EL PASO COUNTY GRADING AND EROSION CONTROL PLAN CHECKLIST

EPC Project Number: PPR-21-46

DUTCH BROS. COFFEE - CO0707 - PEYTON, CO INITIAL EROSION CONTROL PLAN

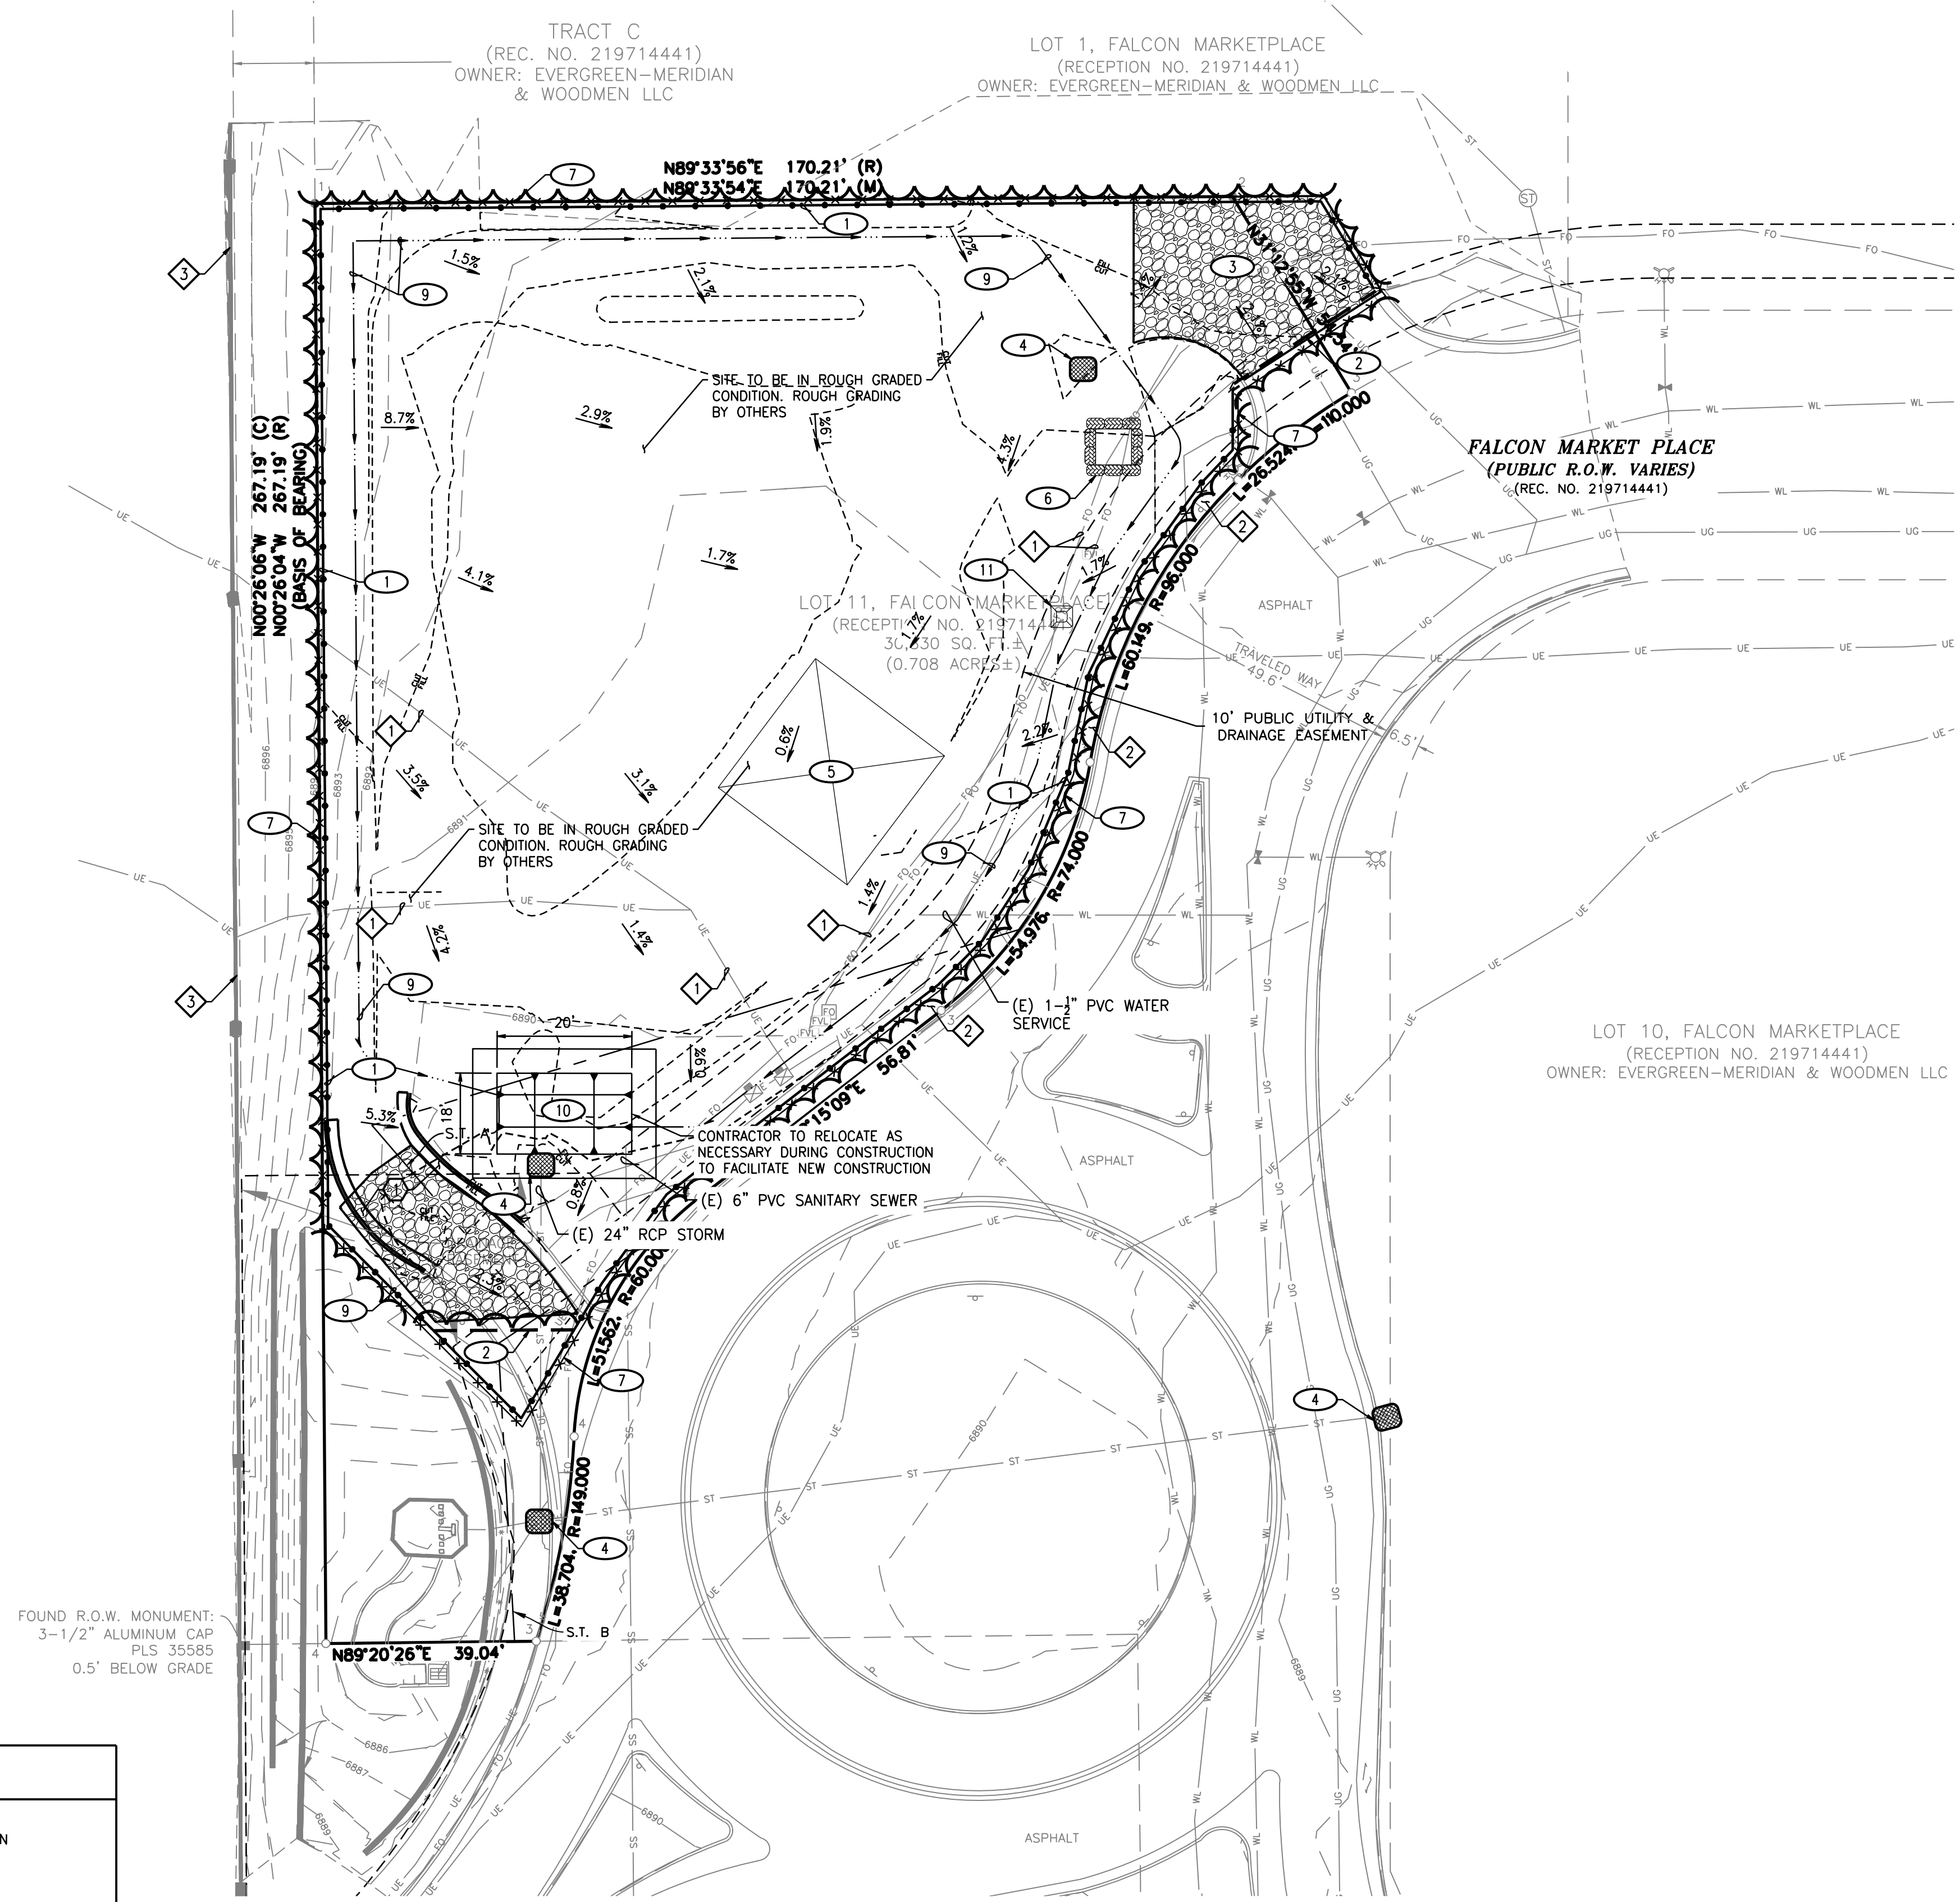
l	Existing and proposed contours 2 feet or less (except for hillside)		✓
m	Limits of disturbance delineating all anticipated areas of soil disturbance		✗
n	Identify and protect areas outside of the construction site boundary with existing fencing, construction fencing or other methods as appropriate		✓
o	Off-site grading clearly shown and called out		✗
p	Areas of cut and fill identified		✓
q	Conclusions from soils/geotechnical report and geologic hazards report incorporated in grading design (slopes, embankments, materials, mitigation, etc.)		✓
r	Proposed slopes steeper than 3:1 with top and toe of slope delineated. Erosion control blanketing or other protective covering required		N/A
s	Stormwater flow direction arrows		✓
t	Location of any dedicated asphalt / concrete batch plants		N/A
u	Areas used for staging, storage of building materials, soils (stockpiles) or wastes. The use of construction office trailers requires PCD permitting		✓

v	All proposed temporary construction control measures, structural and non-structural. Temporary construction control measures shall be identified by phase of implementation to include "initial," "interim," and "final" or shown on separate phased maps identifying each phase		✗
w	Vehicle tracking provided at all construction entrances/exits. Construction fencing, barricades, and/or signage provided at access points not to be used for construction		✓
x	Temporary sediment ponds provided for disturbed drainage areas greater than 1 acre		✓
